**Consultation Response from KC,
Lead Local Flood Authority**

2023/93539 Land adj, Ledgard Bridge Mill, Back Station Road, Mirfield, WF14 8NZ

Date Responded: 27th November 2025

Escape Stair Section 1: 50

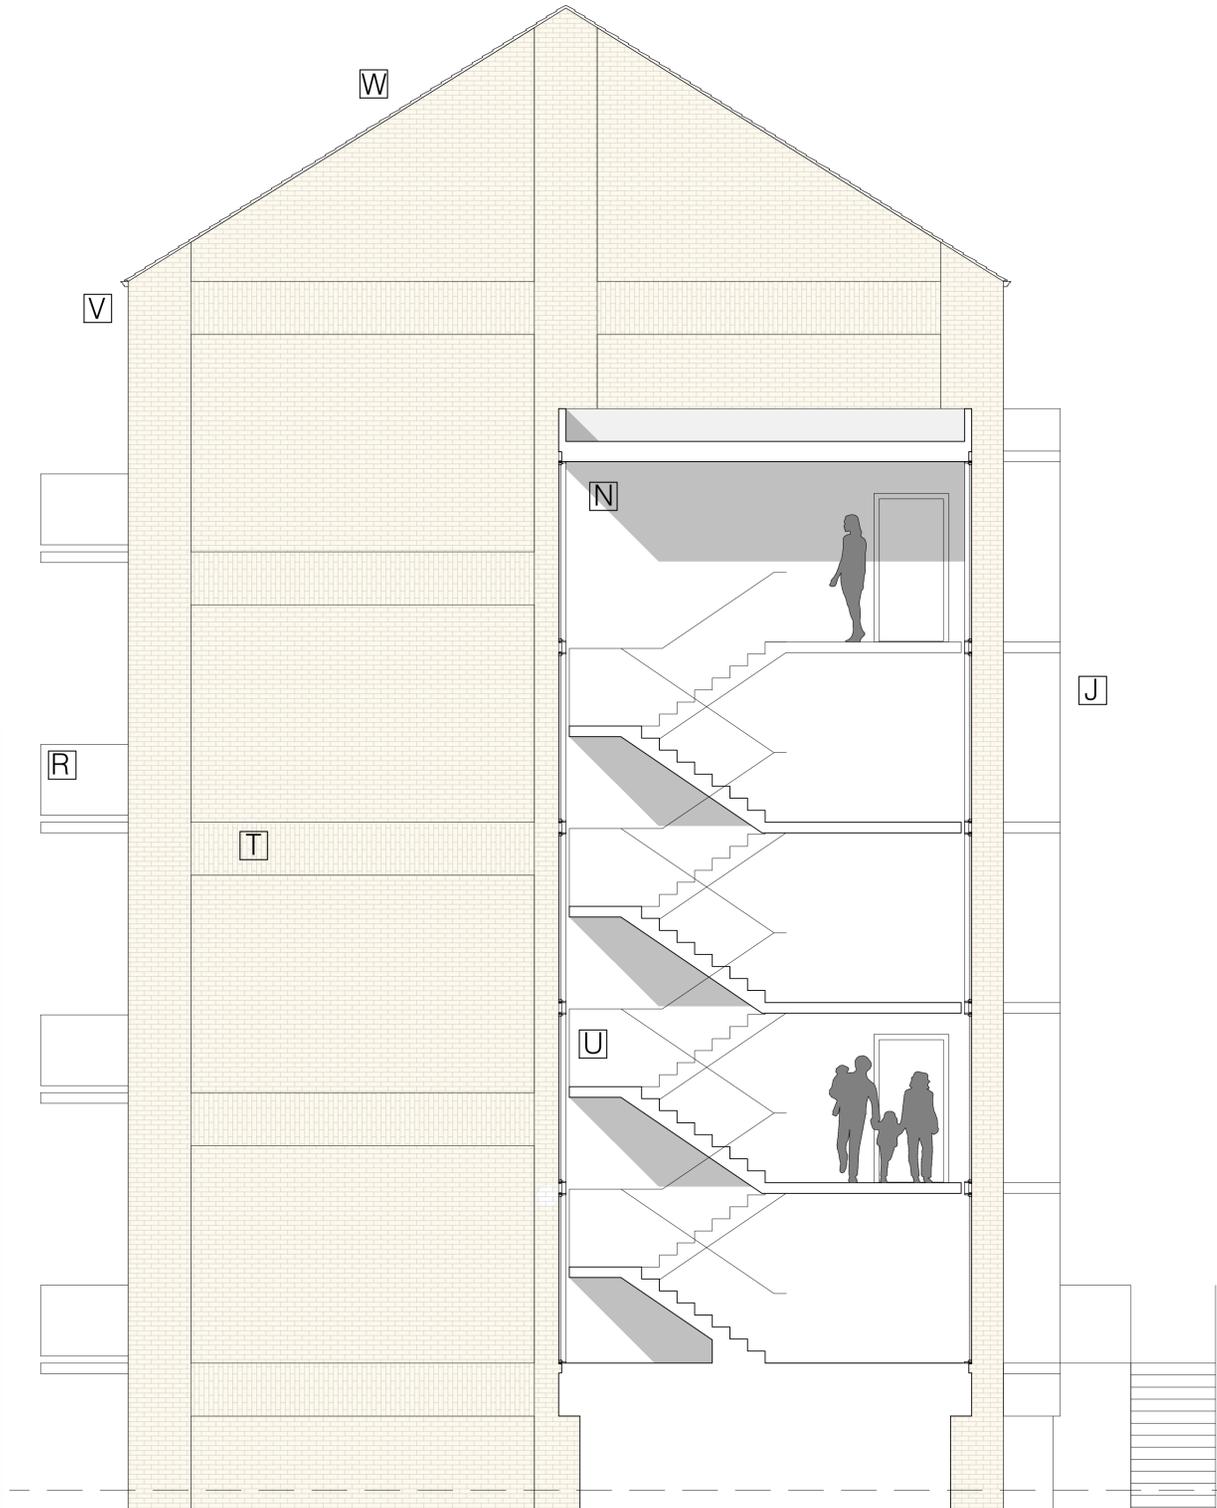
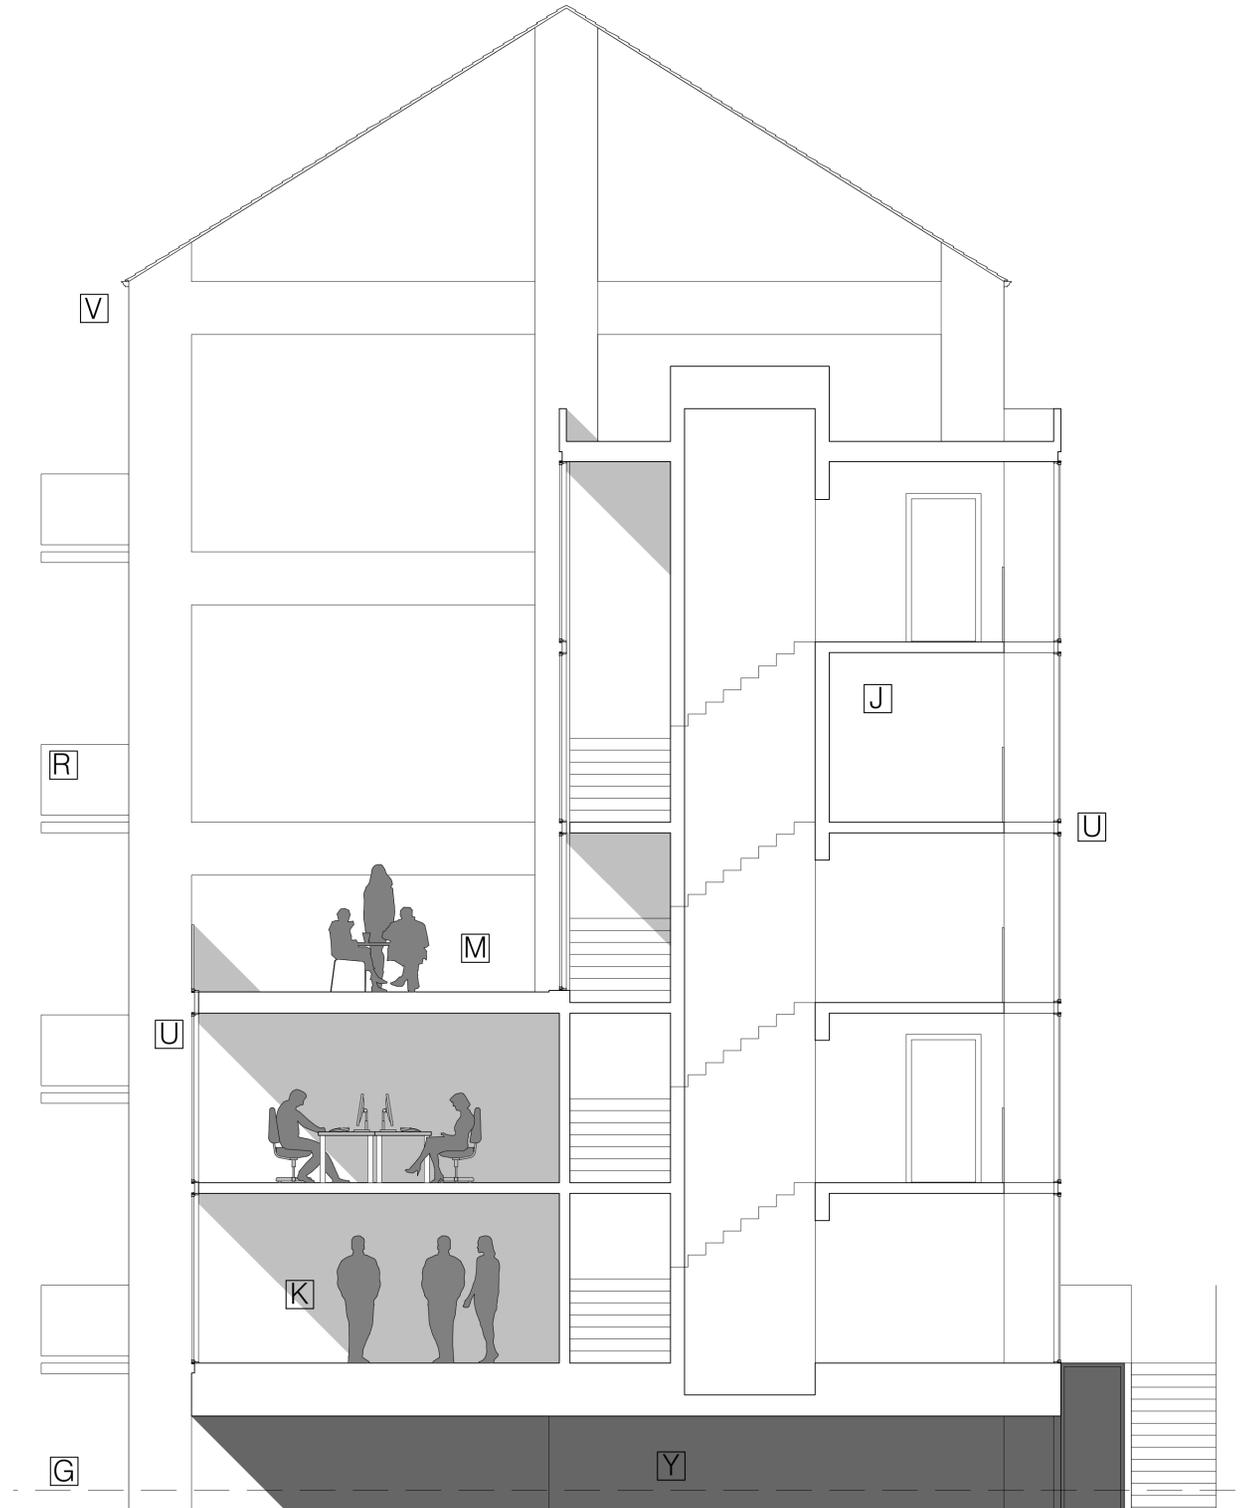
We note that raised walkway now has levels attached but we query why the level of the walkway is lower than the suggested finished floor level of the building. Drawings show steps so we conclude that it not connected to the building and residents may have to still enter flood waters to access it.

This may be an oversight, but drawings should show an exit from the building onto the walkway at the same level as the stipulated minimum finished floor level for the evacuation to be as safe as is reasonably practicable.
